Application no: **3/2022/0162**

Address: **Longridge Cricket Club Chipping Road Longridge PR3 2NB**

Proposal: **Development of new ramp and external viewing area to allow disabled access to clubhouse and terrace.**

The LHA have reviewed PSA Design drawing number S3734-002 Rev P1 titled "Proposed Layouts and Elevations" and understands that the viewing area which will be attached to the existing clubhouse will be 12m wide.

PROPOSED LAYOUT
SCALE 1:100

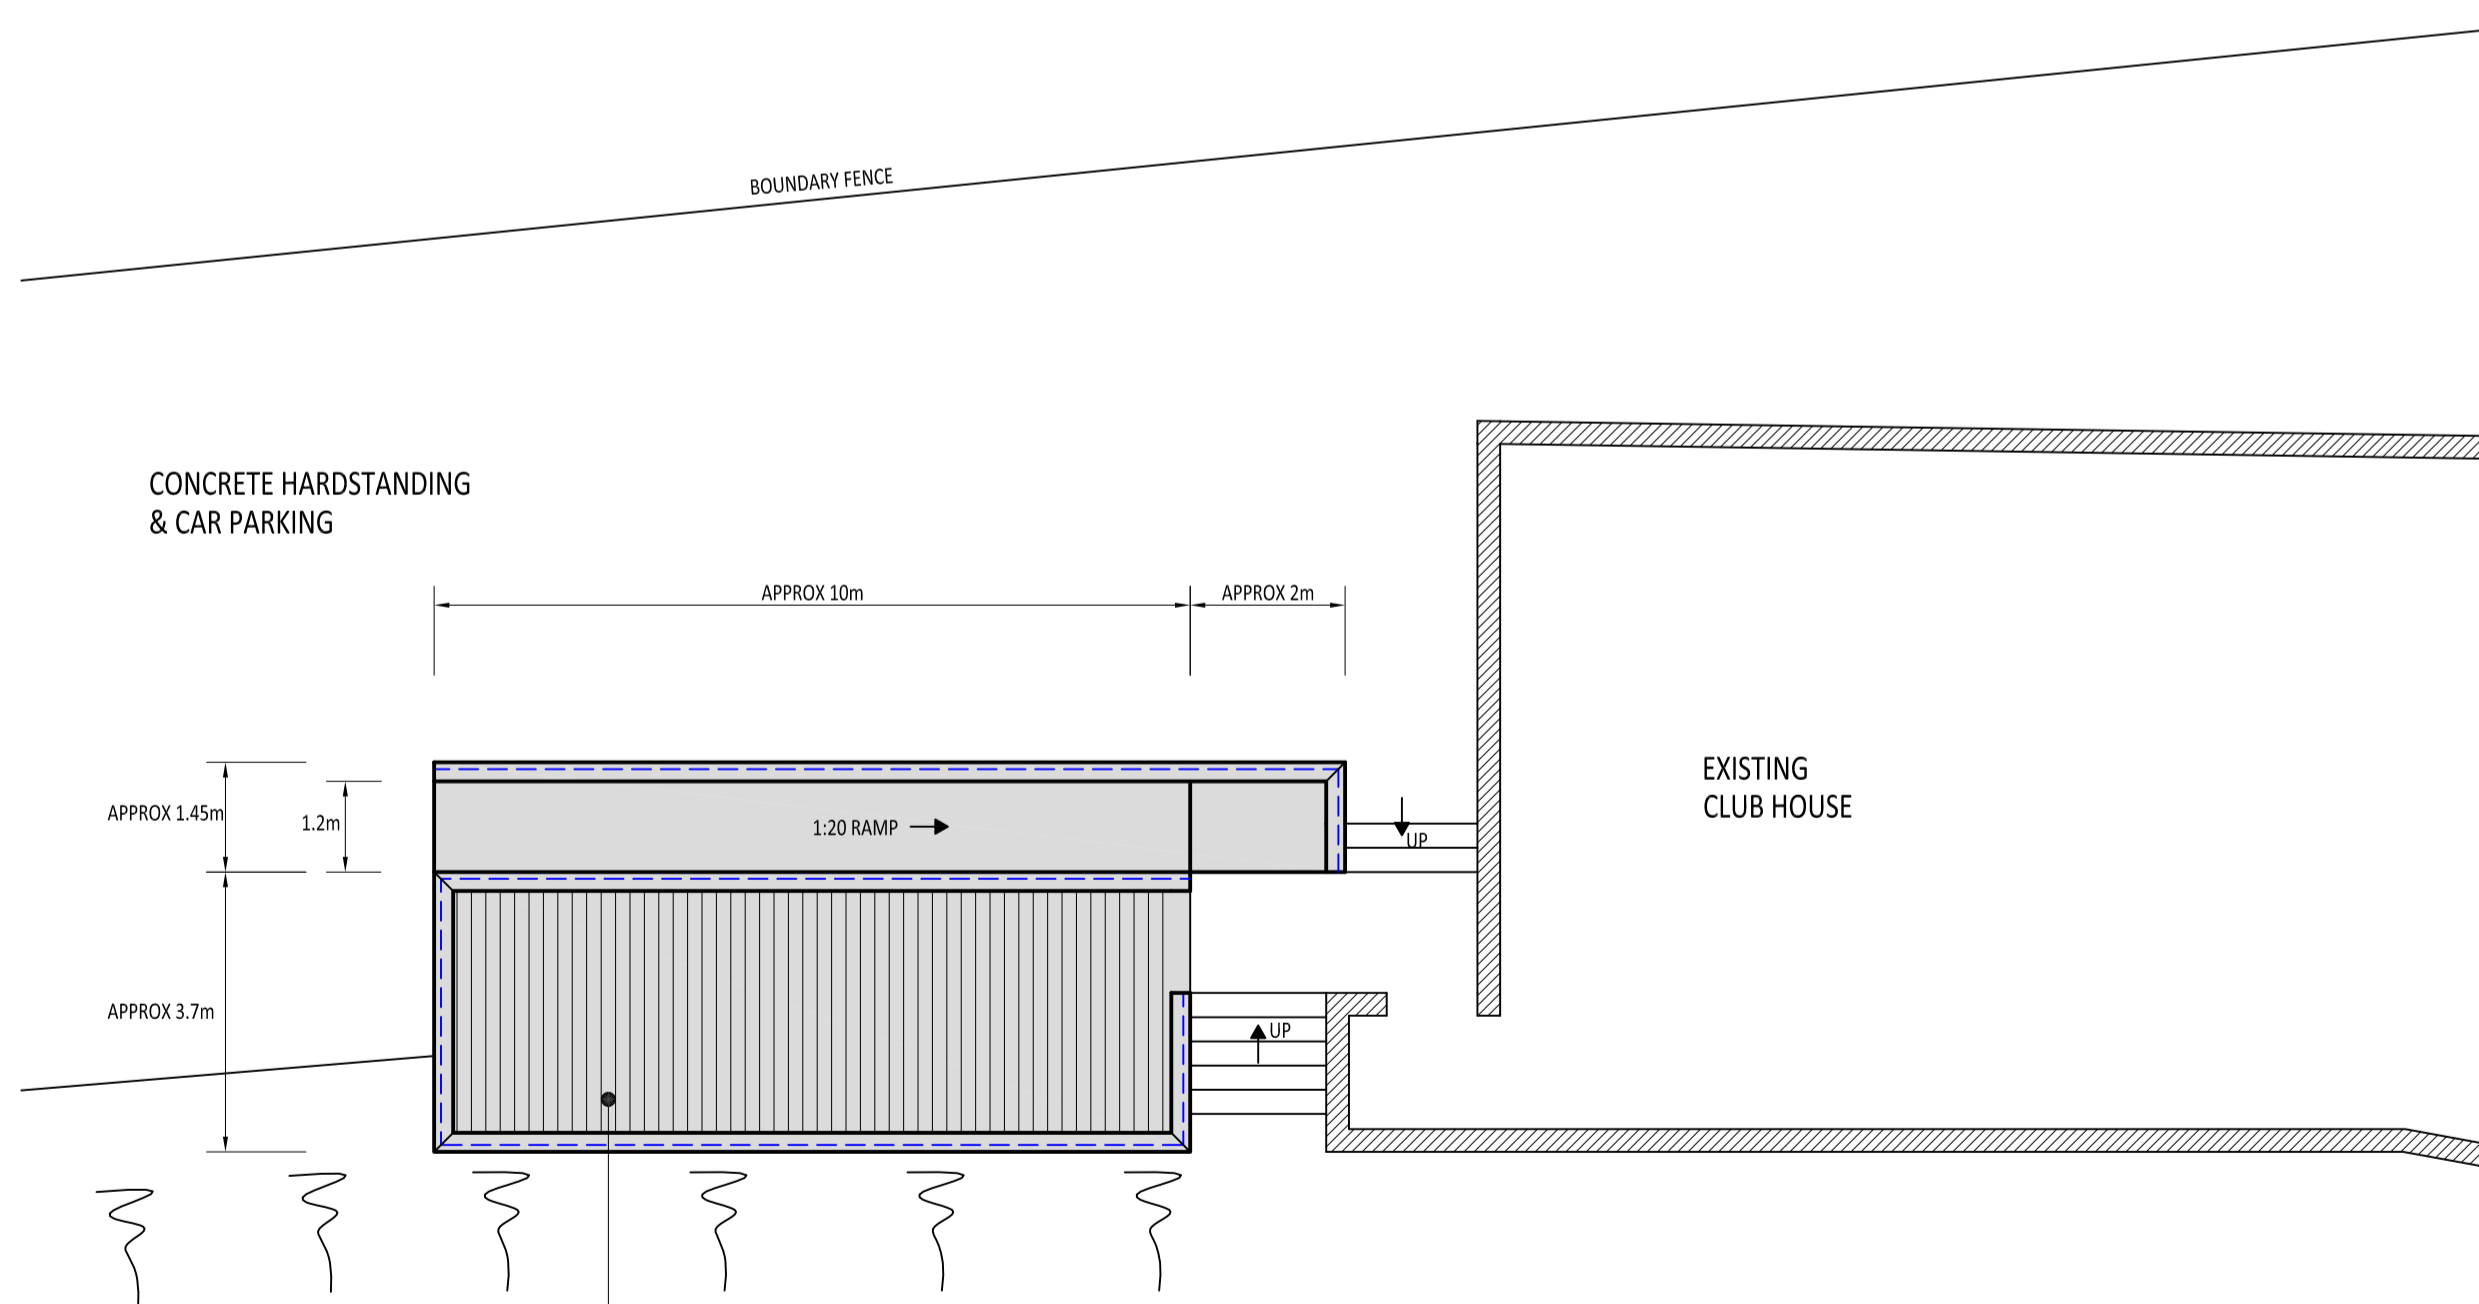
However, the LHA are concerned that the proposed viewing area will displace some existing parking which serves the site in this location. This is because there will not be adequate space for vehicles to reverse out of the hardstanding area behind the proposal. This is because there is only 7.5m between the proposed viewing area and the boundary fence, and so there will only be 2.7m of reversing space, while the LHA require a minimum of 6m. Therefore, the LHA are aware that 5 spaces will be displaced as a result of the proposal.

To counter this and to ensure that the spaces are relocated elsewhere, the LHA require a parking plan of the site to identify how many car parking spaces can be provided at the site. This should be submitted to the LHA.
